# Building R4A (SSD 6964)

## Attachment A – Response to Submissions

Response to Schedule 1: Additional matters identified by the Department of Planning and Environment.

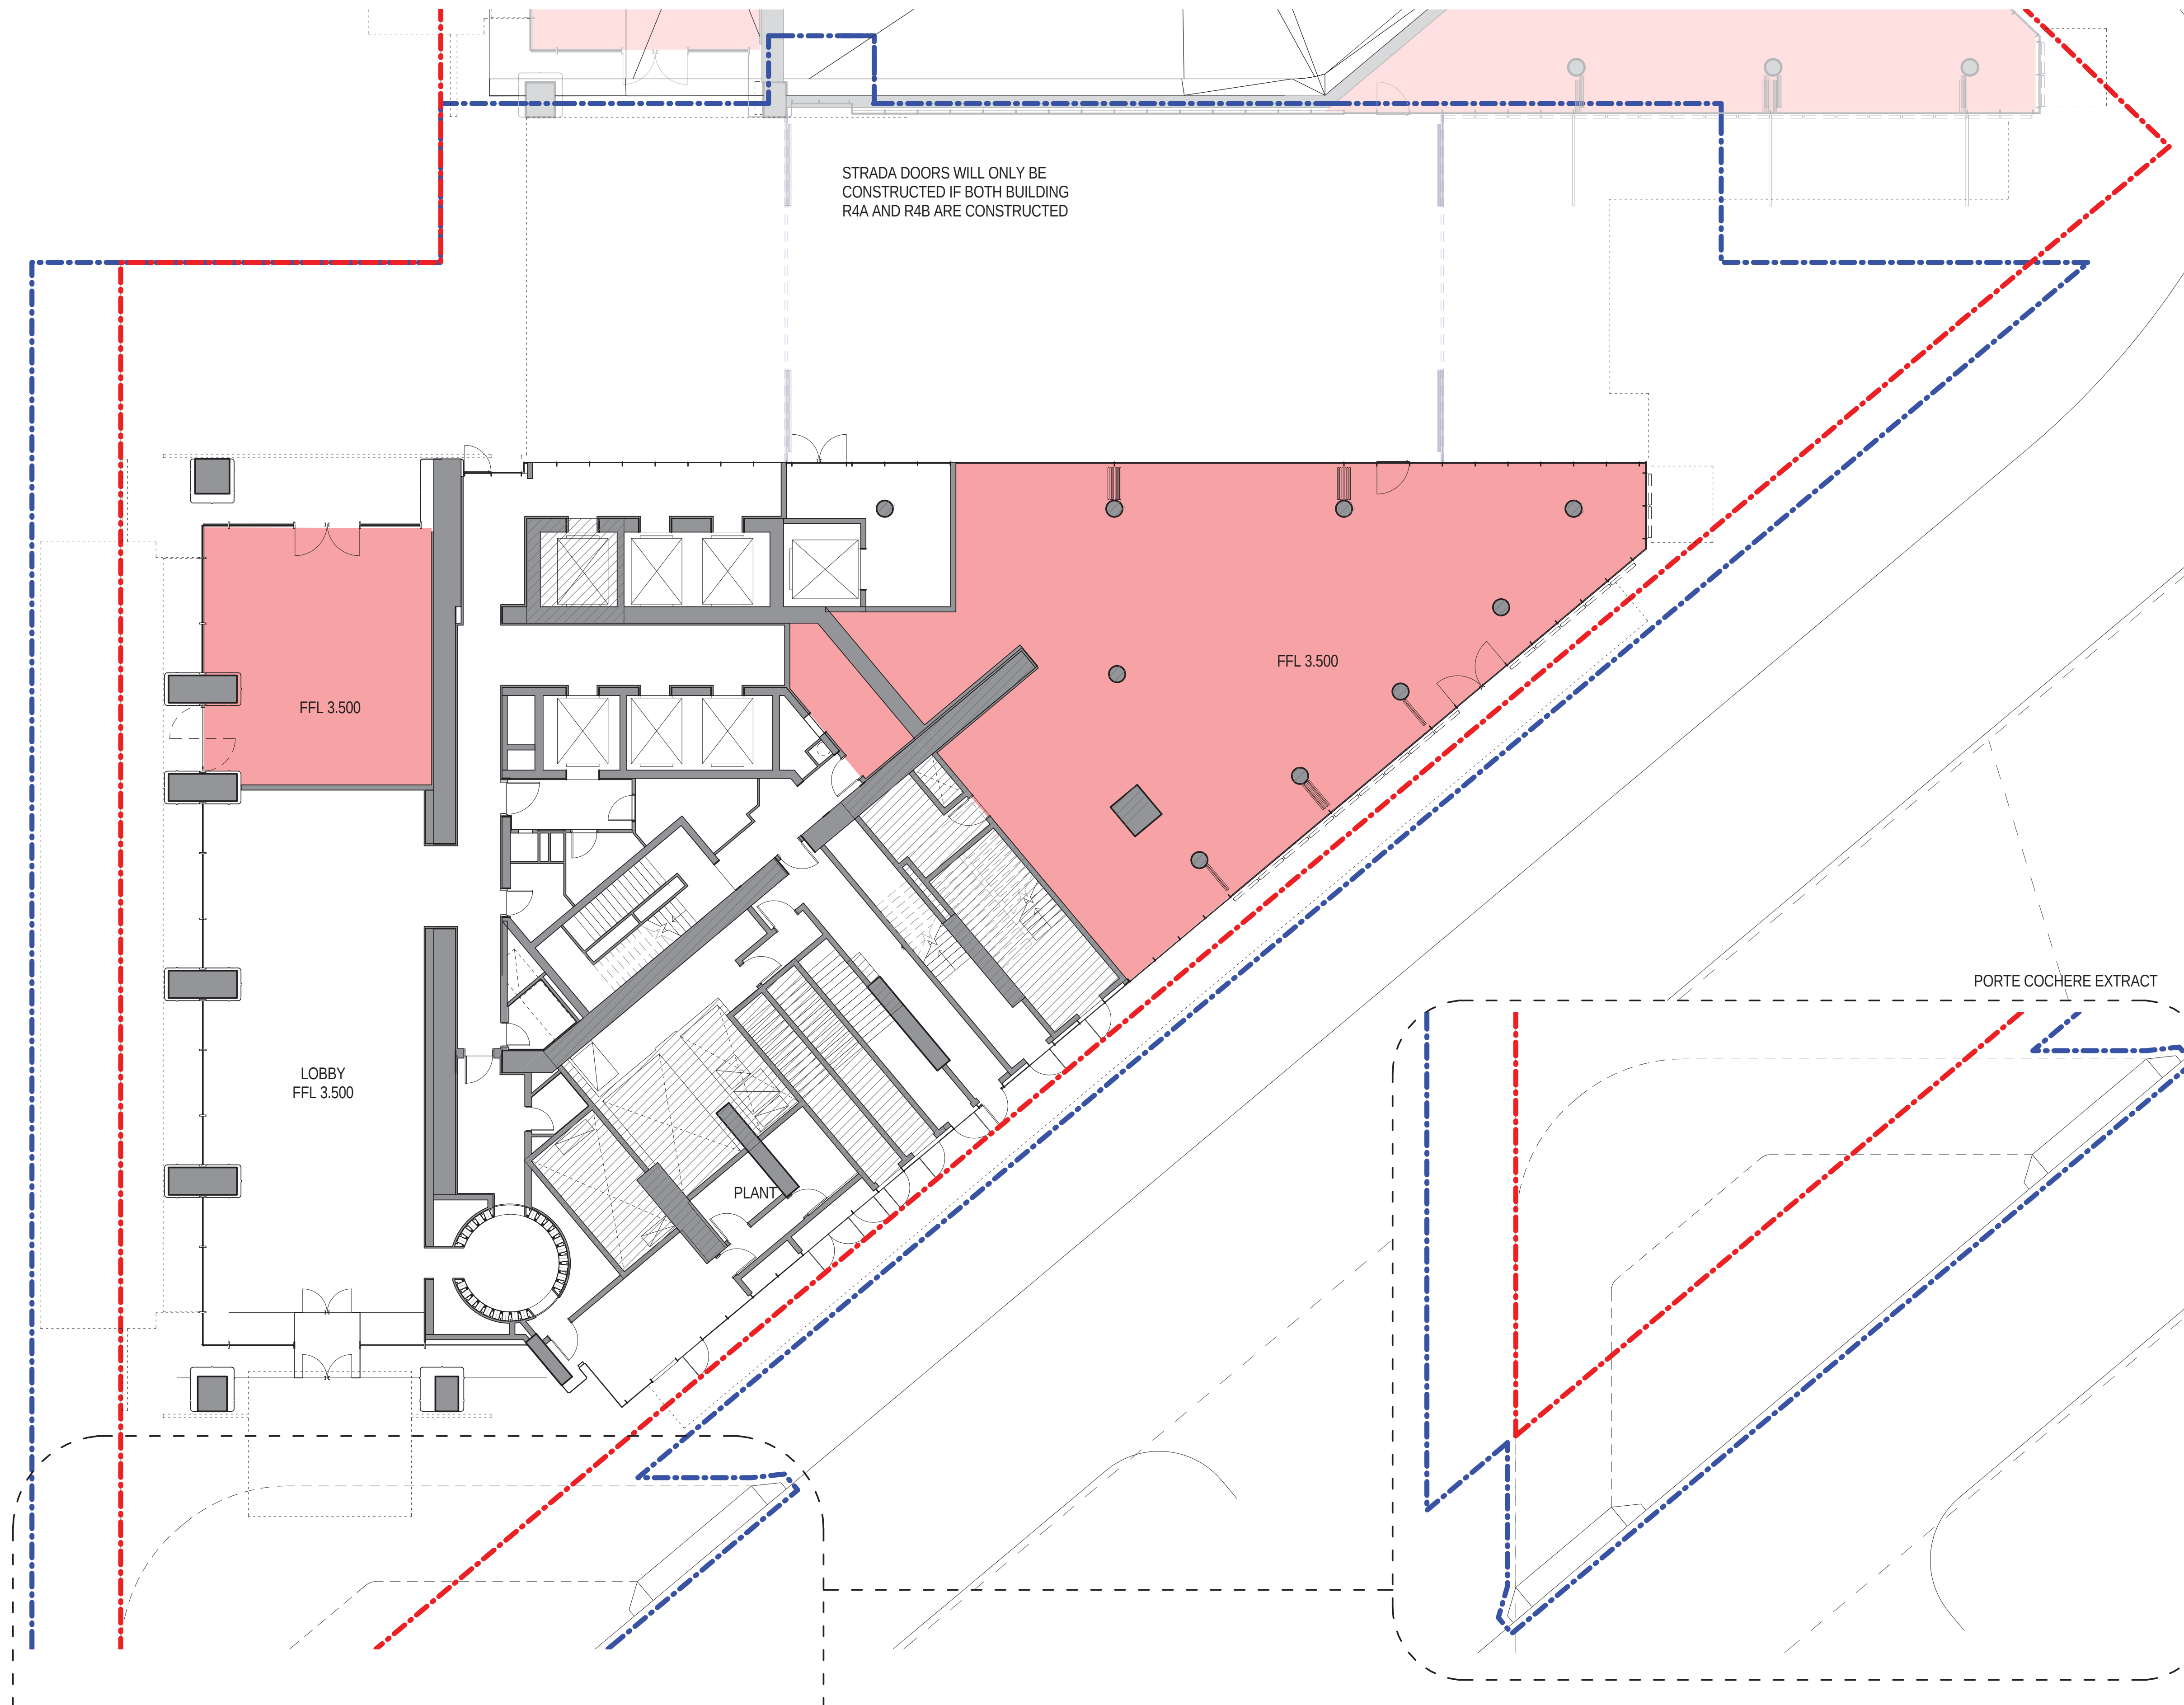
| Key Issues Raised                                                                                                                                                                                                                                                                                                                                                                                                                                                                                                                                                                                                                                                                                                                                                                                                                                                                                                                                                                                                        | Lend Lease Response                                                                                                                                                                                                                                                                                                                                                                                                                                                                                                                                                                                                                                                                                                                                                                                                                                                                                                                                                                                                                                                                                                                                                                                                                                                                                                                                                                                                                                                                                                                                                                                               |
|--------------------------------------------------------------------------------------------------------------------------------------------------------------------------------------------------------------------------------------------------------------------------------------------------------------------------------------------------------------------------------------------------------------------------------------------------------------------------------------------------------------------------------------------------------------------------------------------------------------------------------------------------------------------------------------------------------------------------------------------------------------------------------------------------------------------------------------------------------------------------------------------------------------------------------------------------------------------------------------------------------------------------|-------------------------------------------------------------------------------------------------------------------------------------------------------------------------------------------------------------------------------------------------------------------------------------------------------------------------------------------------------------------------------------------------------------------------------------------------------------------------------------------------------------------------------------------------------------------------------------------------------------------------------------------------------------------------------------------------------------------------------------------------------------------------------------------------------------------------------------------------------------------------------------------------------------------------------------------------------------------------------------------------------------------------------------------------------------------------------------------------------------------------------------------------------------------------------------------------------------------------------------------------------------------------------------------------------------------------------------------------------------------------------------------------------------------------------------------------------------------------------------------------------------------------------------------------------------------------------------------------------------------|
| <p><u>Canopy</u></p> <p>The “Strada canopy” between buildings R4B and R4A effectively encloses and privatises the public domain between these buildings. This is contrary to the Concept Plan and not supported from an urban design perspective. It is not in the public interest to enclose and privatise this space.</p> <p>The link bridge between R4B and R4A is not supported, irrespective of whether the strada canopy is built or not. Upper level links are discouraged in the Sydney CBD. Instead, the City encourages pedestrians to traverse the streets at ground level, to enliven, activate and participate in city life.</p> <p>Little detail is provided relating to the strada canopy and link bridge, by way of architectural design, materials and finishes.</p> <p>The design should be amended to remove the canopy and overbridge link and the creation of public open space between R4A and R4B. Awnings for pedestrian protection should be installed rather than a canopy and overbridge.</p> | <p>The area between R4A and R4B to be known as “The Strada” provides a direct public link between the public domain at Watermans Cove and Hickson Park. The Strada has been deliberately designed to ensure that it is able to provide a pleasant pedestrian environment at all times, taking into account variable weather conditions and the need to provide protection from wind, rain or harsh sunlight. Retail and restaurant tenancies along the Strada benefit from the ability to provide seating both within the podium and outdoors, encouraging visitors into the area and minimising any harsh demarcation between public and private land.</p> <p>To protect the amenity of this predominantly outdoor space all year round, the Strada incorporates a glazed covering as well as retractable doors to be used to mitigate inclement weather conditions. These components ensure that there will be a space that provides a high level of amenity to pedestrians and visitors to the area, regardless of weather conditions.</p> <p>It must be noted that the Barangaroo South Built Form and Urban Design Controls approved under Concept Plan Mod 8 designate this pedestrian link as secondary. Contrary to Council's comments, the Concept Plan (as modified) does not prohibit the provision of a canopy or link bridge between Buildings R4A and R4B.</p> <p>Further discussion on the Strada is provided in the covering Response to Submissions Report and greater details on the design of the Strada are provided at <b>Appendix C</b> of the covering Response to Submissions Report.</p> |

R4A and R4B Proximity Diagram

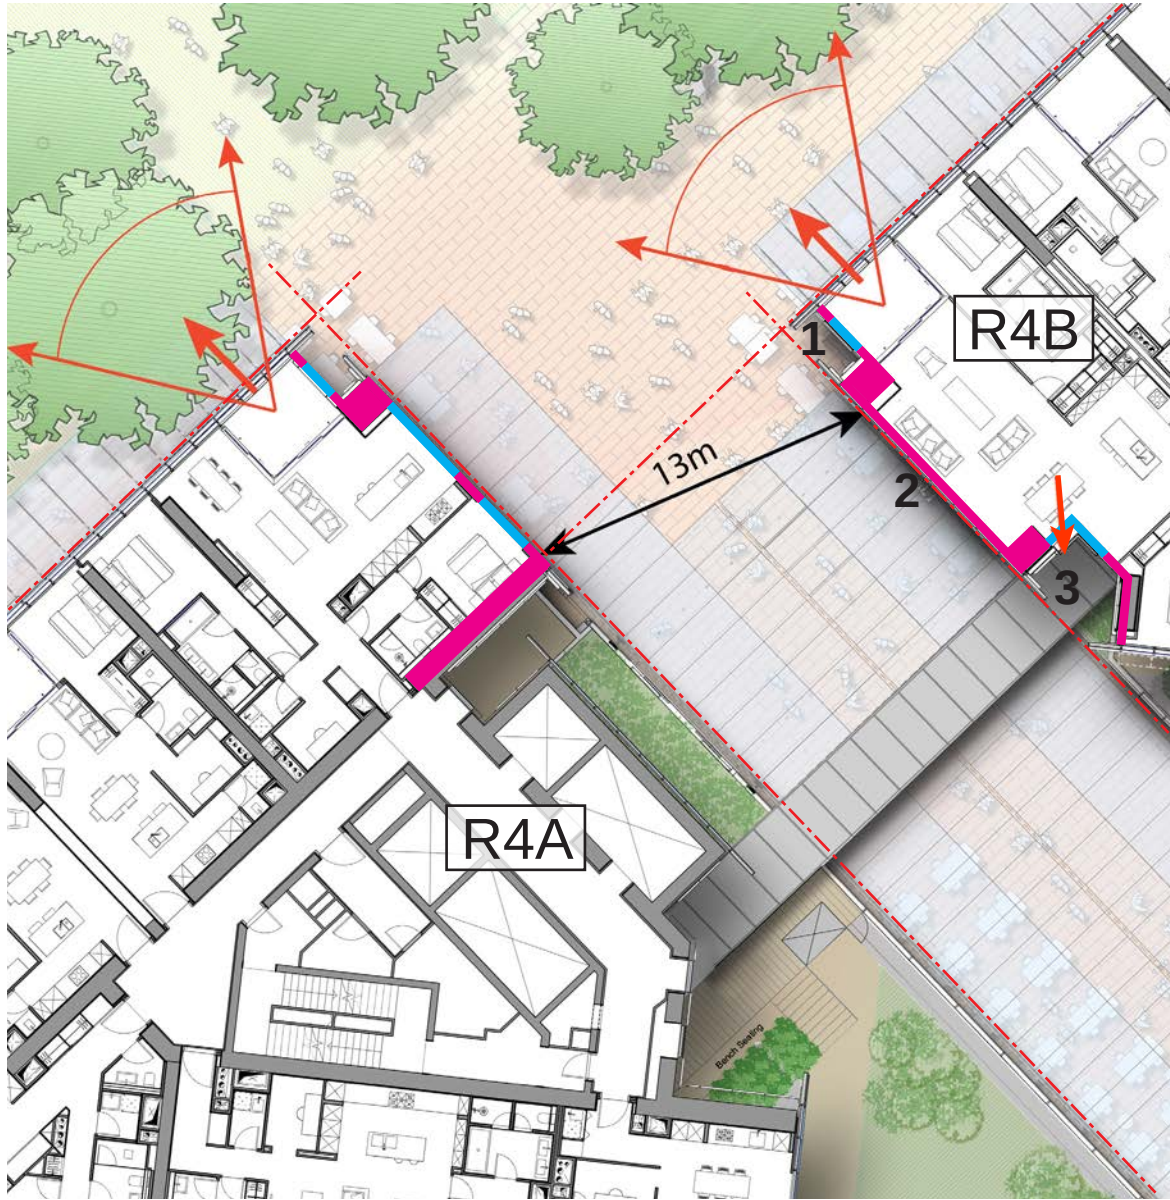
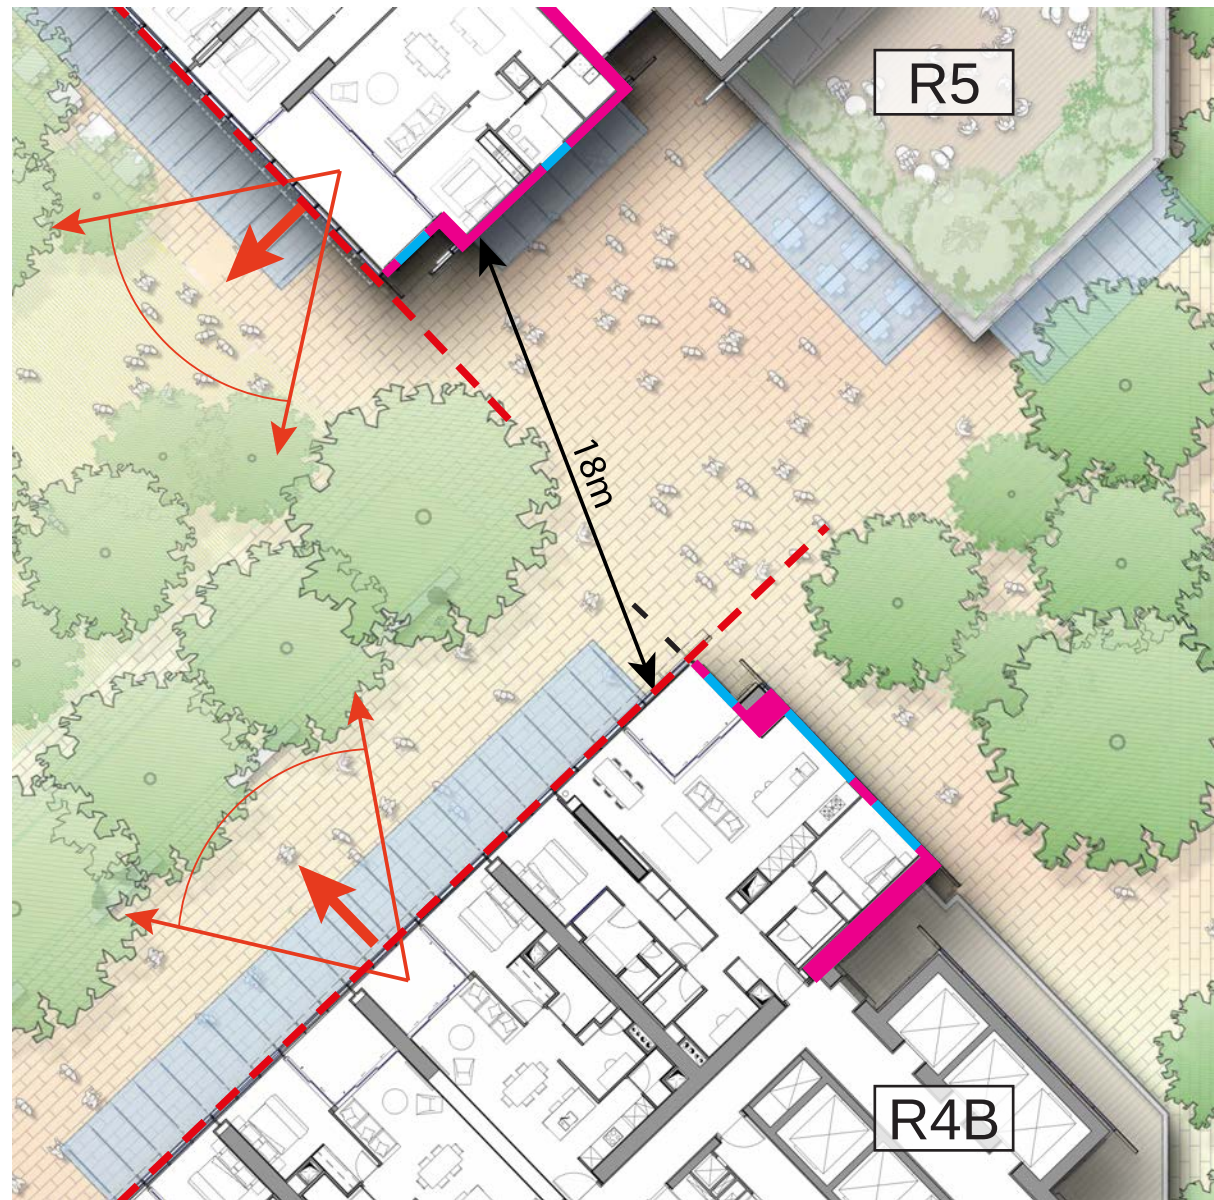
| Key Issues Raised                                                                                                                                                                                                                                                                                                                                                                                                                                                                                                                                                                                                                                                                                                                                                                                                                                                                                                                                                                                                                                                                                                                                           | Lend Lease Response                                                                                                                                                                                                                                                                                                                                                                                                                                                                                                                                                                                                                                                                                                                                                                                                                                                                                                                                                                                                                                                                                                                                                                                                                                                                                                                                                                                                                                                                                                                                                                                                                                |
|-------------------------------------------------------------------------------------------------------------------------------------------------------------------------------------------------------------------------------------------------------------------------------------------------------------------------------------------------------------------------------------------------------------------------------------------------------------------------------------------------------------------------------------------------------------------------------------------------------------------------------------------------------------------------------------------------------------------------------------------------------------------------------------------------------------------------------------------------------------------------------------------------------------------------------------------------------------------------------------------------------------------------------------------------------------------------------------------------------------------------------------------------------------|----------------------------------------------------------------------------------------------------------------------------------------------------------------------------------------------------------------------------------------------------------------------------------------------------------------------------------------------------------------------------------------------------------------------------------------------------------------------------------------------------------------------------------------------------------------------------------------------------------------------------------------------------------------------------------------------------------------------------------------------------------------------------------------------------------------------------------------------------------------------------------------------------------------------------------------------------------------------------------------------------------------------------------------------------------------------------------------------------------------------------------------------------------------------------------------------------------------------------------------------------------------------------------------------------------------------------------------------------------------------------------------------------------------------------------------------------------------------------------------------------------------------------------------------------------------------------------------------------------------------------------------------------|
| <p><u>Non Compliance with SEPP 65 - Compliance with the Apartment Design Guide</u></p> <p>The design of the apartments results in non-compliances with the Apartment Design Guideline. The apartment yield is excessive and non-compliances should be excised from the proposals.</p> <p><u>Building separation</u></p> <p>The proposed design does not meet the objectives of the Apartment Design Guide in relation to building separation. The proposed minimum separation distance between R4A and R4B is 13m, which is 11m less than is required 24m separation in the ADG. The opaque façade to provide privacy to the R4B living rooms is likely to diminish the outlook amenity for all apartments.</p> <p>The detail of the opaque façade and opaque privacy screen is unknown, as well as how effective these features will be in providing visual privacy.</p> <p>The design should be amended to ensure no habitable rooms or balconies are located facing one another between R4A and R4B and that buildings meet minimum separation distances.</p> <p>Detailed drawings of windows and materials should also be provided at a 1:50 scale.</p> | <p>A detailed assessment against the ADG is provided in the report prepared by Renzo Piano Building Workshop and Lendlease Design at <b>Appendix C</b> and a detailed discussion of the ADG is included in the covering Response to Submissions report. The assessment provided in the Response to Submissions report determines that the proposed development is acceptable and when considered holistically the proposals provide a high level of amenity consistent with the objectives of the ADG.</p> <p>A detailed discussion on this matter is provided in the covering Response to Submissions report. The proposal is in accordance with the Concept Plan (as modified) and the Barangaroo South Built Form and Urban Design Controls. The proposal also achieves the objectives of the ADG by offsetting outlook and providing materiality/screening to sensitive areas where privacy issues may have occurred. The opaque façade provided to some apartments in Building R4B will not adversely diminish outlook as residents will still be able to obtain outlook to other directions.</p> <p>These are detailed design features which will be confirmed in greater detail during the Construction Certificate process, as is standard practice.</p> <p>As outlined above, the proposed development is in accordance with the Concept Plan (as modified) and the Barangaroo South Built Form and Urban Design Controls. The proposal also achieves the objectives of the ADG, therefore is acceptable.</p> <p>Detailed drawings of windows and materials at 1:50 scale will be prepared prior to the commencement of construction.</p> |
